From: Harry Chalk
Sent: 08 December 2025 14:59
To: Planning.Responses
Subject: FW: LU/193/25/PL - Courtwick Park, Courtwick Lane
Attachments: H2070- ADG- ZZ- XX- DR- A-9012 - Proposed Site Plan - Boundary Plots
08Dec25.pdf

From: john.bell <[REDACTED]>
Sent: 08 December 2025 14:08
To: Harry Chalk <Harry.Chalk@arun.gov.uk>
Cc: Zoe Jackson <[REDACTED]>
Subject: RE: LU/193/25/PL - Courtwick Park, Courtwick Lane

1. Could I request clarification as to the intended plot boundaries? I note the hard landscaping plan has close boarded fencing illustrated to designate what I assume are the intended gardens. Noting the report for the previous decision found harm in plots having gardens heavily dominated by mature and protected trees. However, the proposed site plan isn't clear what the extents of the residential plots would be. I think it would be helpful to firstly clarify the extents of the plots, but to also seek a plan shading the dedicated residential plot areas so that we can consider whether restrictions to things like PD rights would be necessary. I.e. if one of the gardens of the plots encloses an abundance of TPO trees, do we need to restrict outbuildings/hard surfacing etc.

7 Silvertown Court, Northumberland Business Park, NE23 7RY 0191 5877679		
Client		
Caring Homes		
Job Title		
Courtwick Park Courtwick Lane Littlehampton		
Drawing Title		
Drainage Strategy Sheet 2		
Scale at A1		
1:250		
Drawing Status		
PRELIMINARY		
Job No	Drawing No	Issue
21090	201	P8

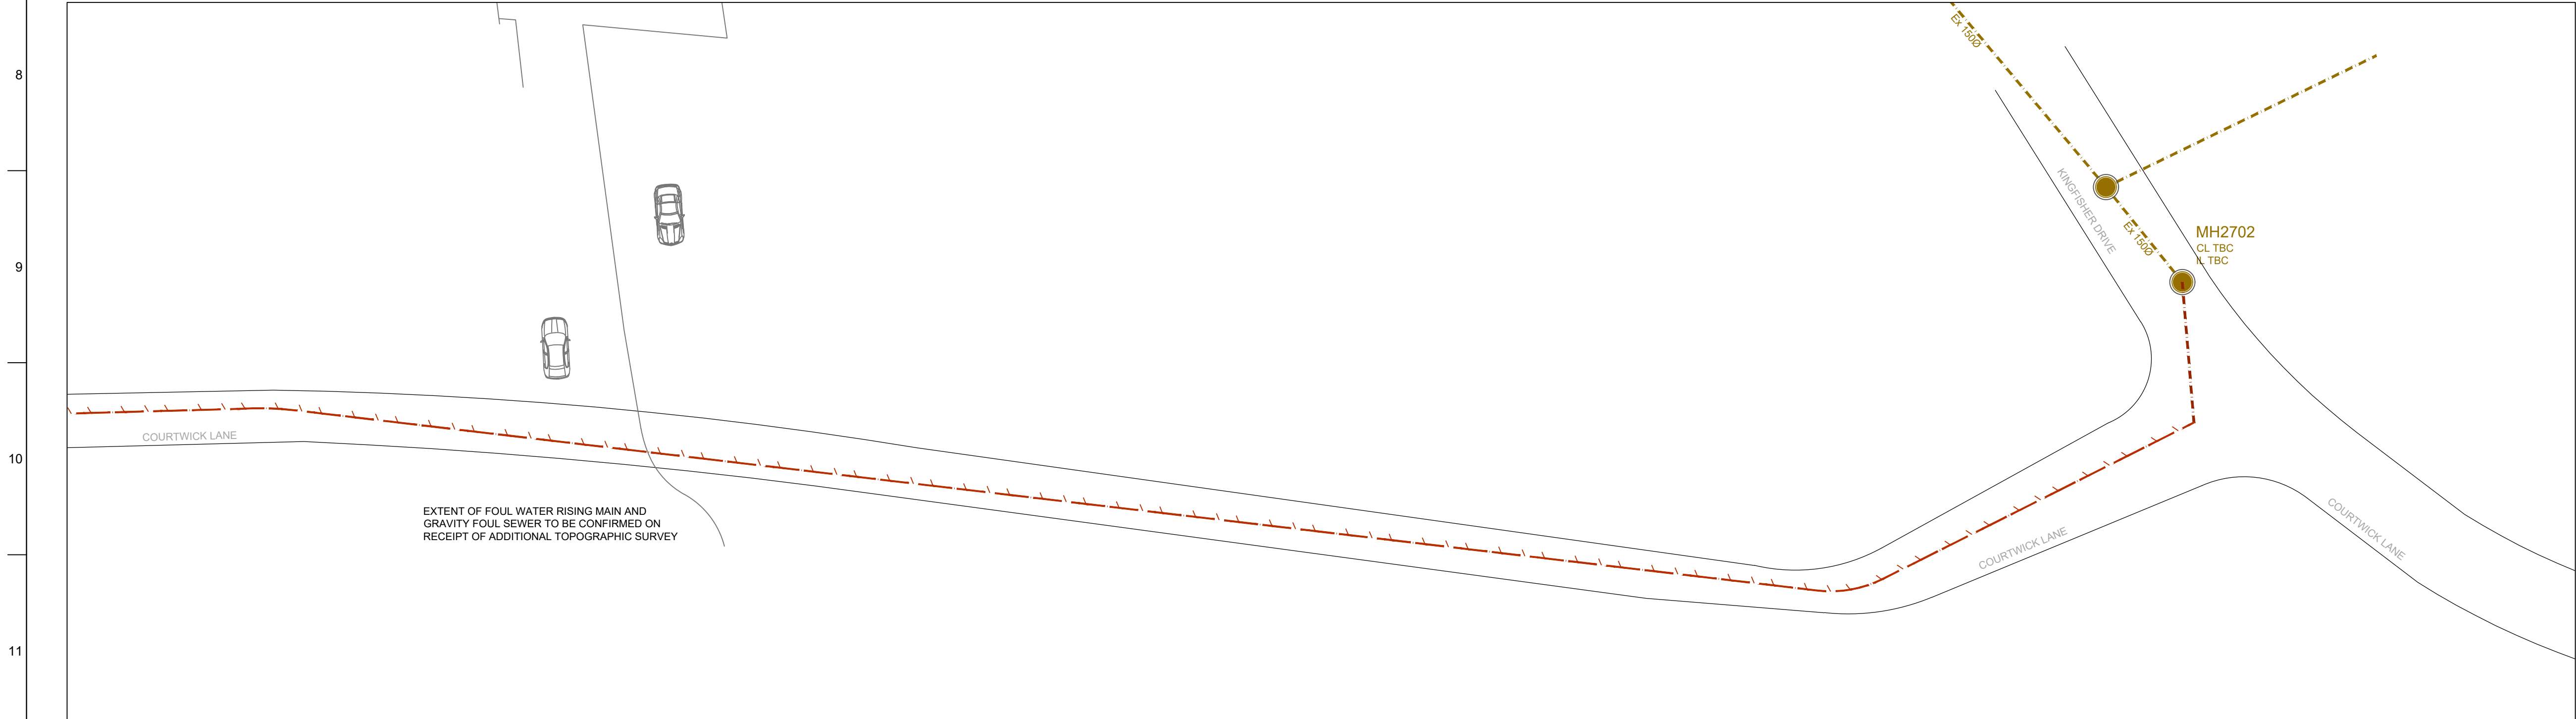
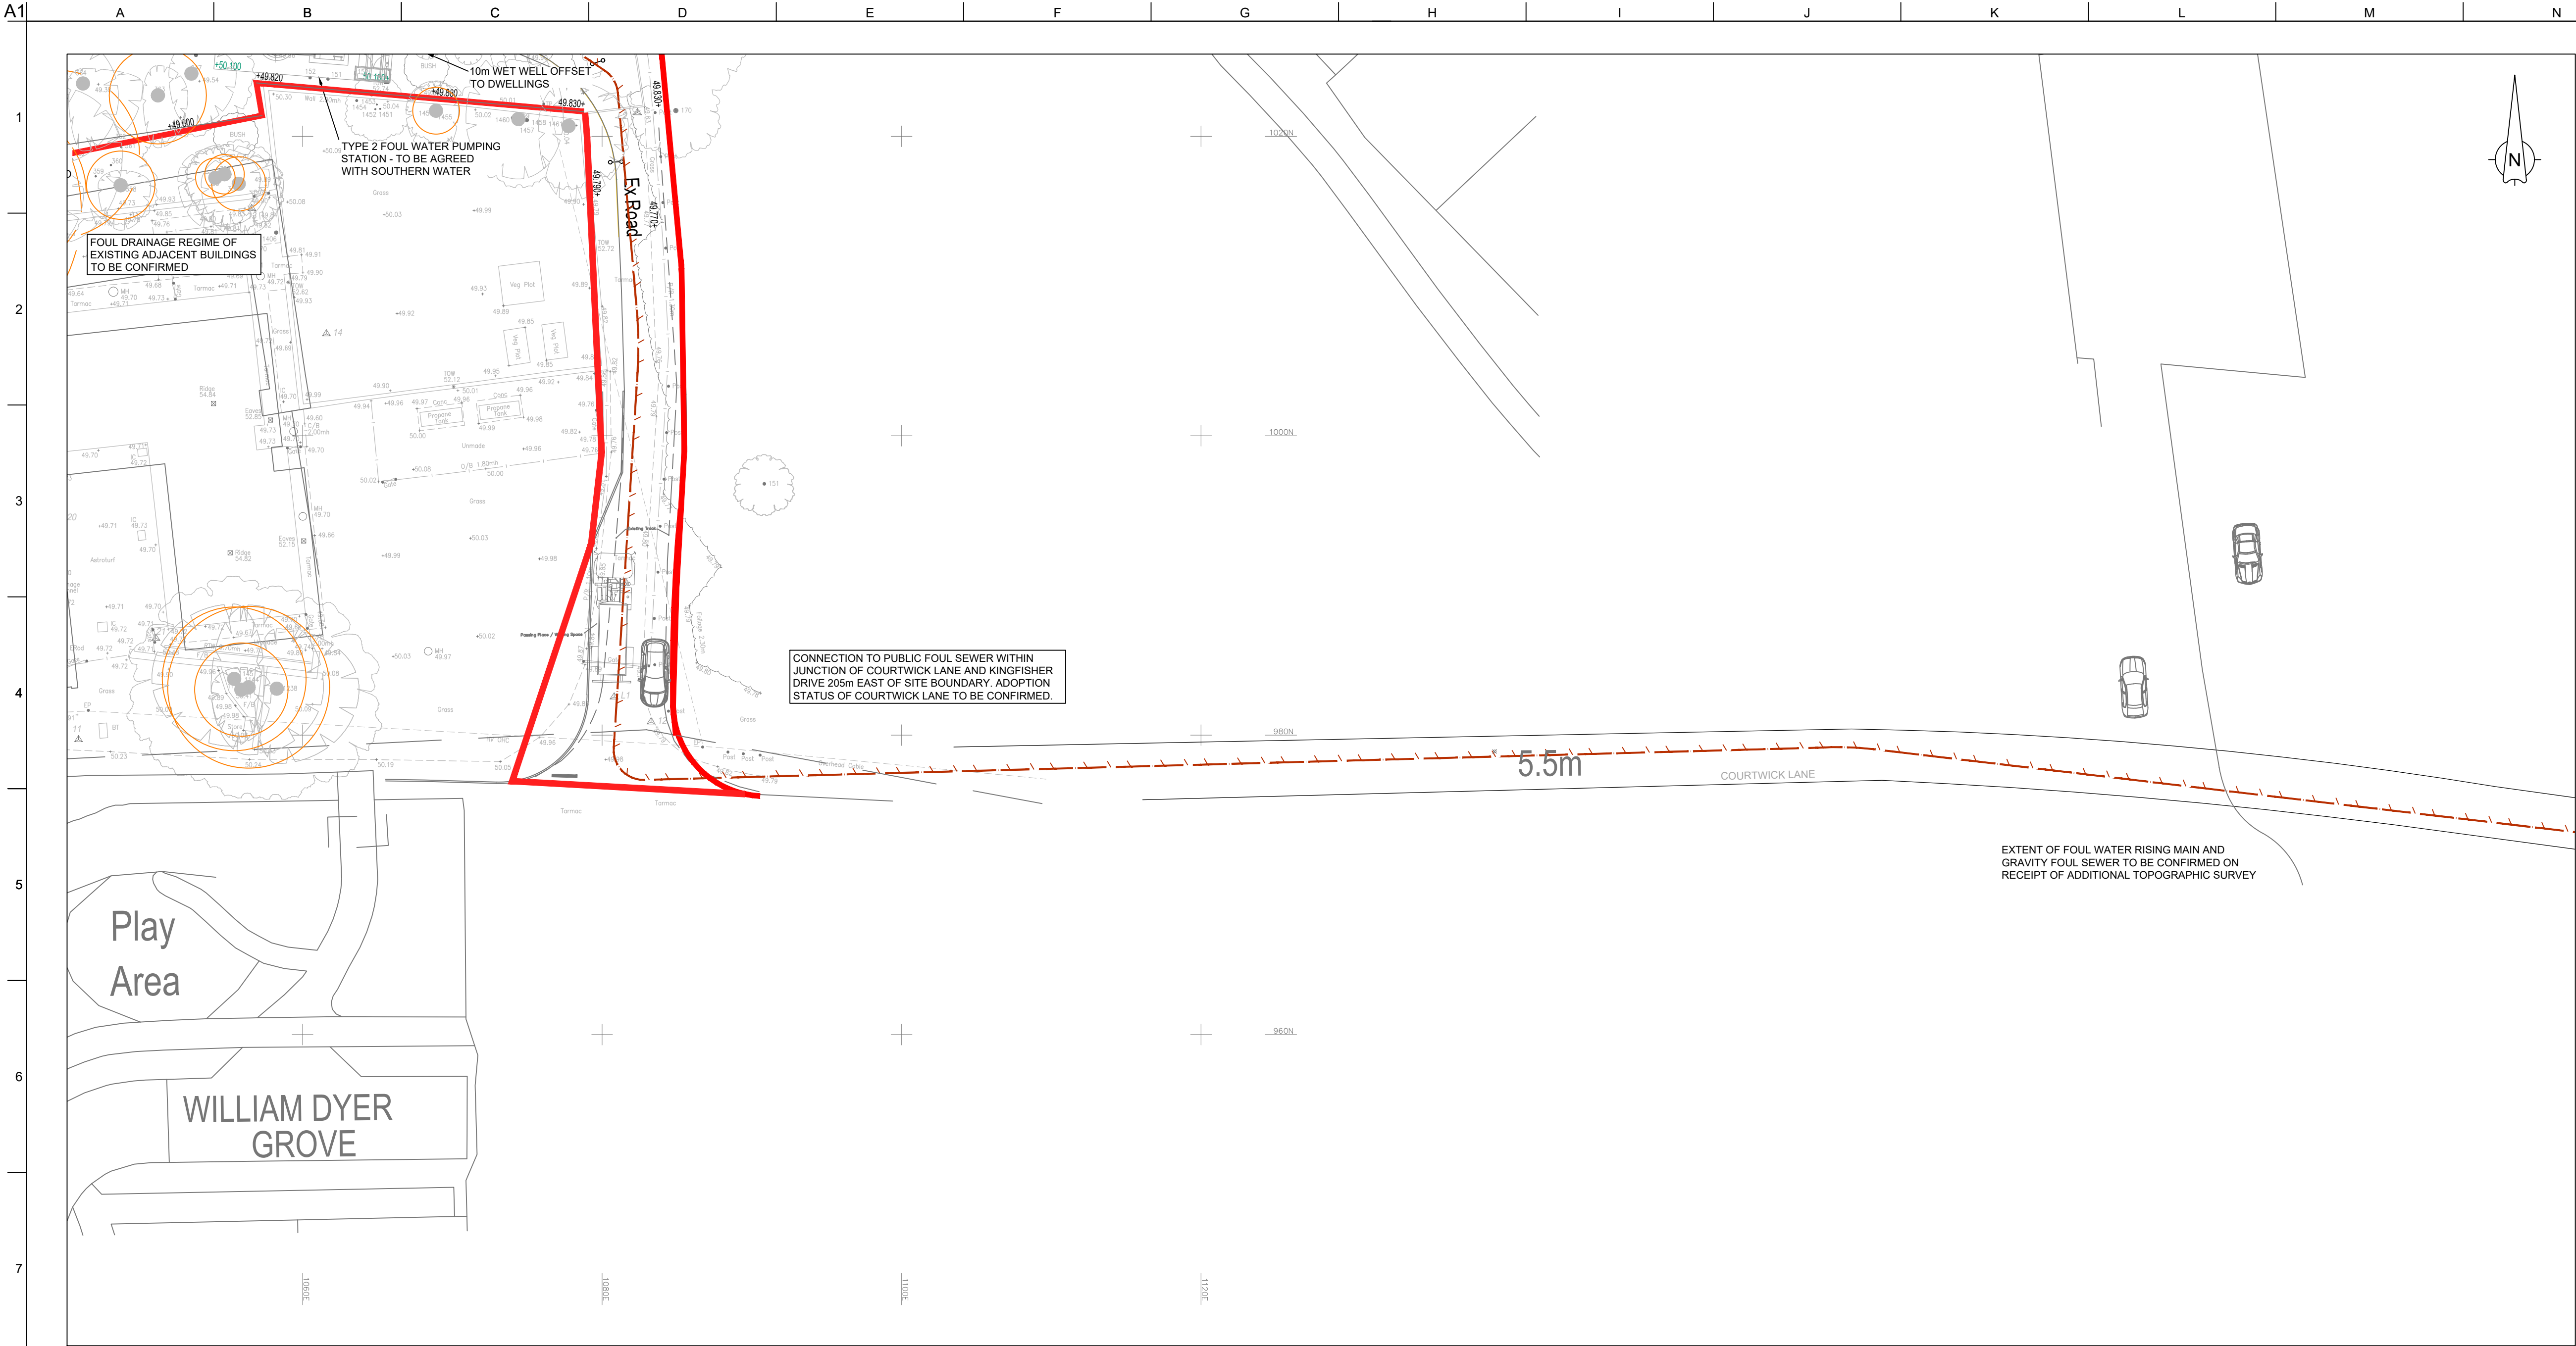
2. My second query pertains to the 'No Dig' construction methods proposed for the road, particularly within T09's RPA. I am unclear how permeable asphalt/block paving could be installed without excavation or alteration to land levels within the RPA as identified. Some clarity on this would be appreciated.

Query 2 – In the tree report, recommendations section 7.4 this is itemised in the AIA section 3.0 the method statement. The process we have outlined is in line with the processes and methods detailed within BS5837. In short; a no dig permeable service is installed by not digging into the ground, turf can be removed under supervision, and then the permeable layers are built up as dictated in BS5837.
